Our Case Number: ACP-323410-25

Re: Proposed Limerick City Greenway (UL to NTP)
Within the townlands of Dromroe, Sreelane, Newcastle and Castletroy, Co. Limerick.

Our Ref: TC/SC/5674. Case Ref. HA91.323410

RE: The proposed Limerick City Greenway (UL to NTP) in the townlands of Dromroe,
Screelane, Newcastle and Castletroy, Co. Limerick - Limerick City & County Council.
Our client: Mrs. Rose Donovan, Skehana, Creora, Co. Limerick.

PLATE NO.10

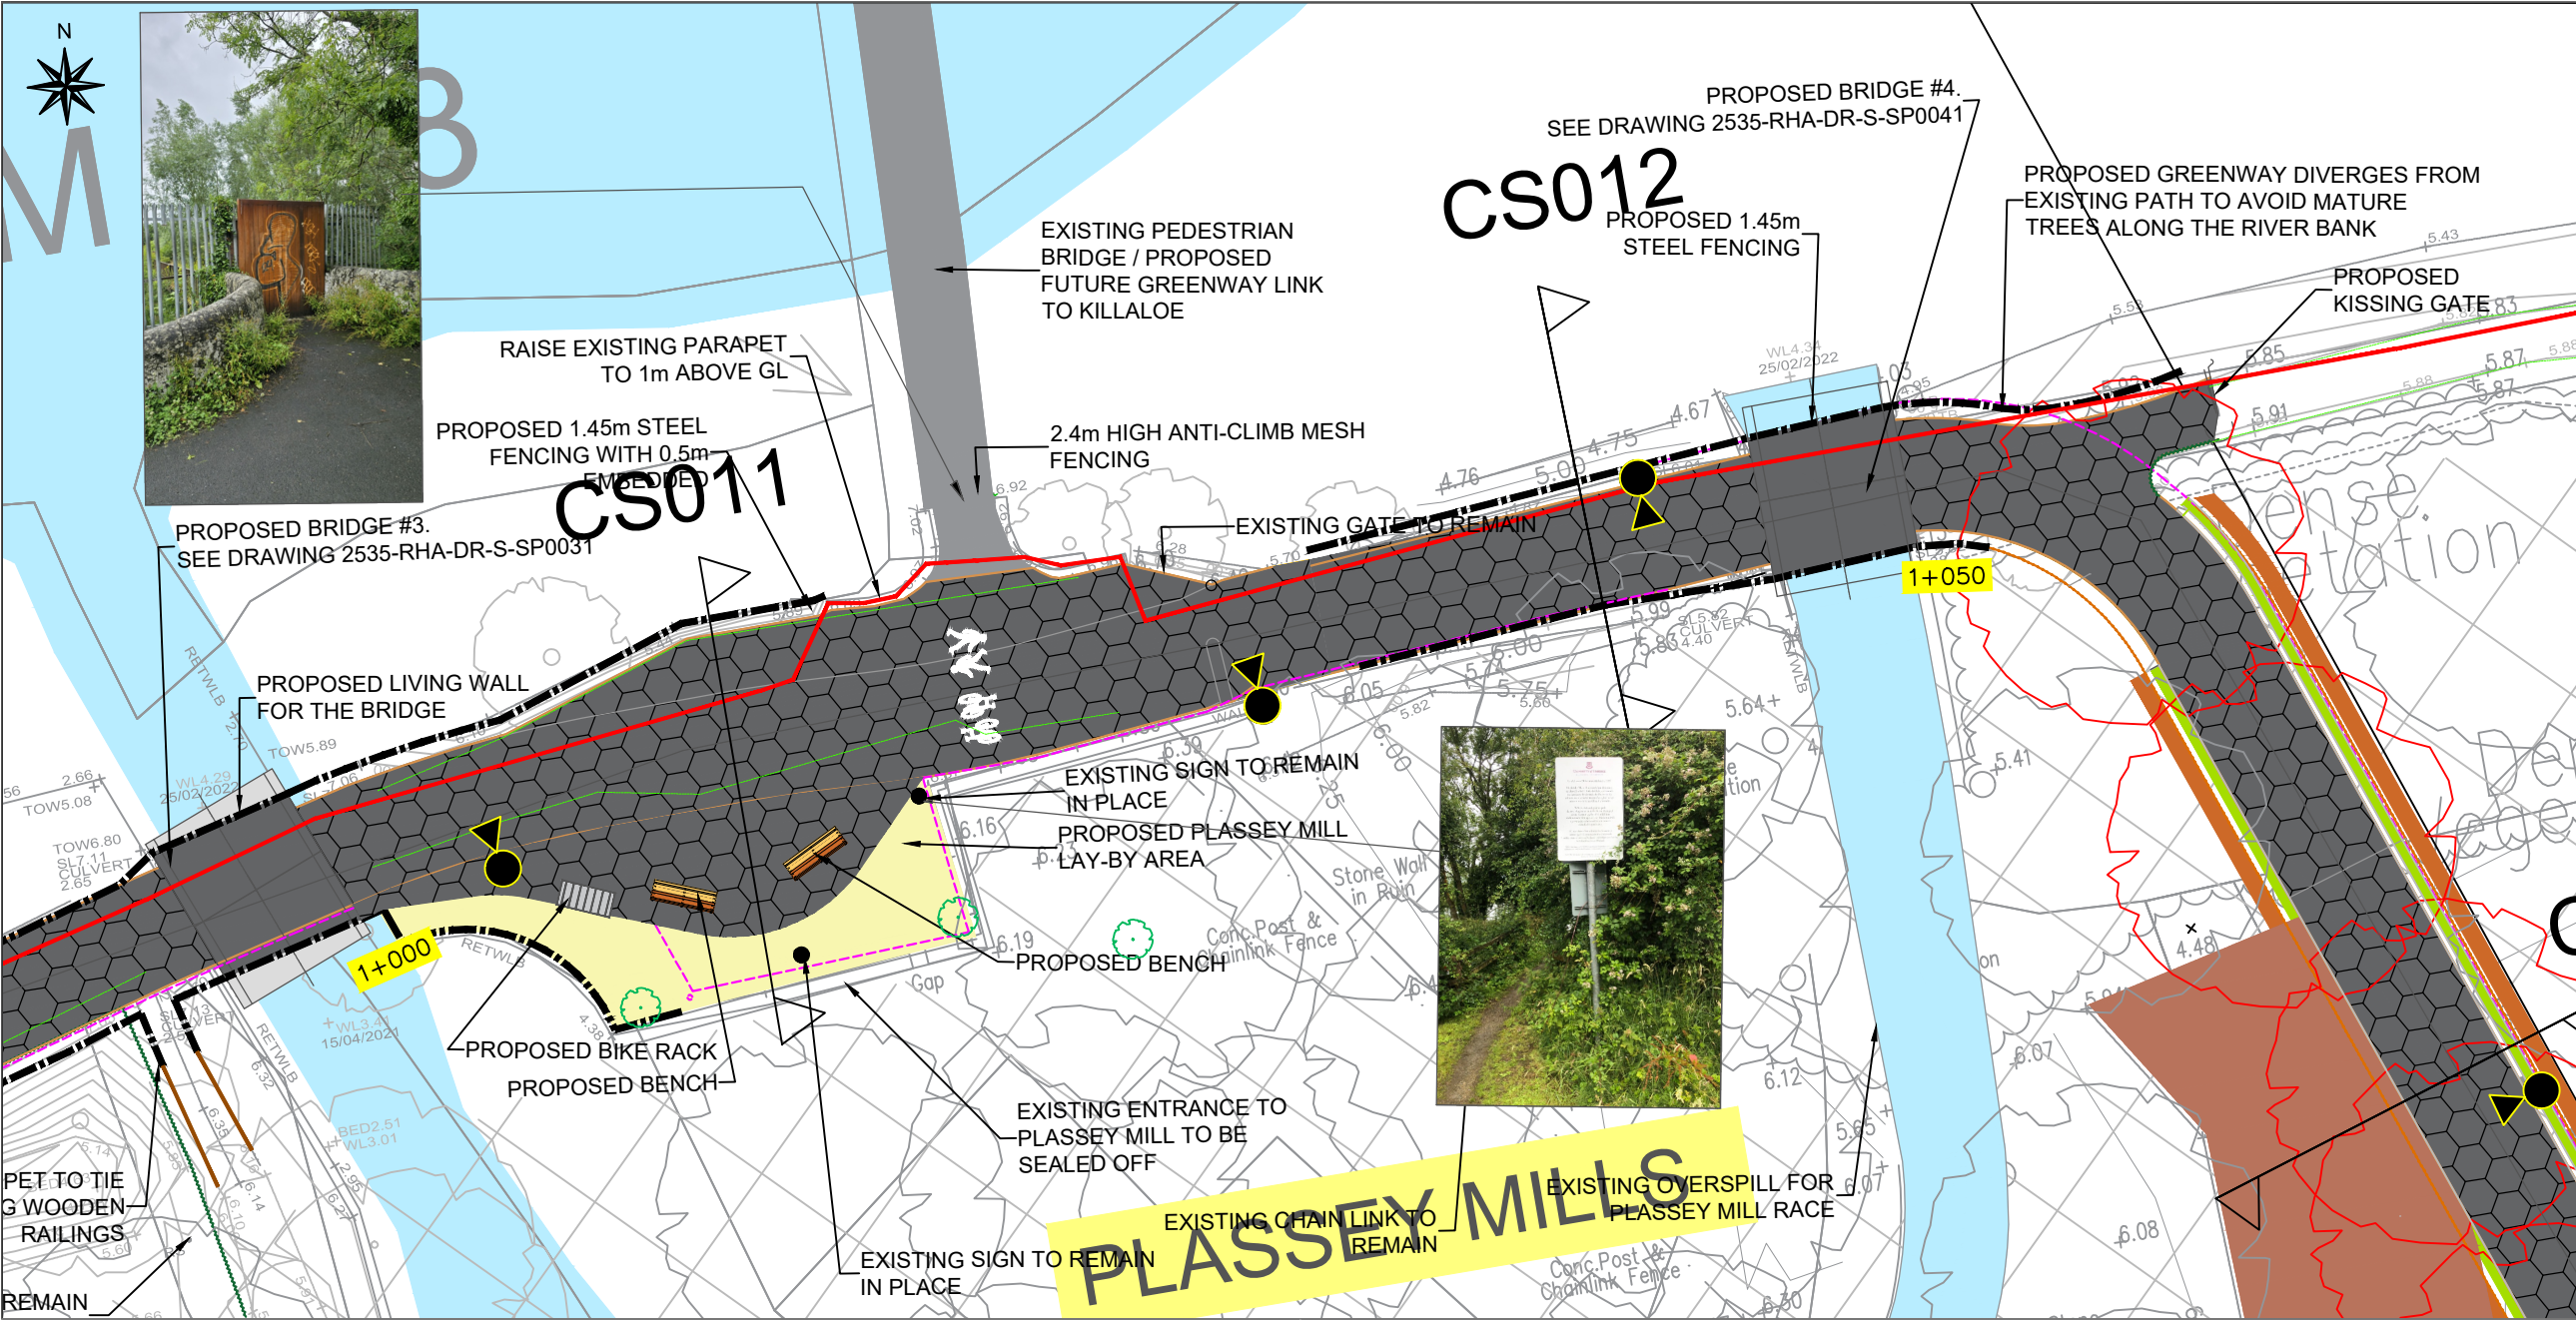
We act on behalf of the above mentioned client who is the owner of the land at Screelane (near Plassey Mills) though which the proposed greenway is shown to run on plate no. 10 & 11

We attach a copy of our client's title maps (part of the title is registry of deeds and the remaining part is contained in Folio LK73770F). Our client has not been approached by Limerick City & County Council in relation to provision of consent for the proposed greenway to run through her lands. The proposed greenway as shown traversing our client's landholding will render parts of our client's land inaccessible due to the proposed 1.4m fencing shown on the plans.
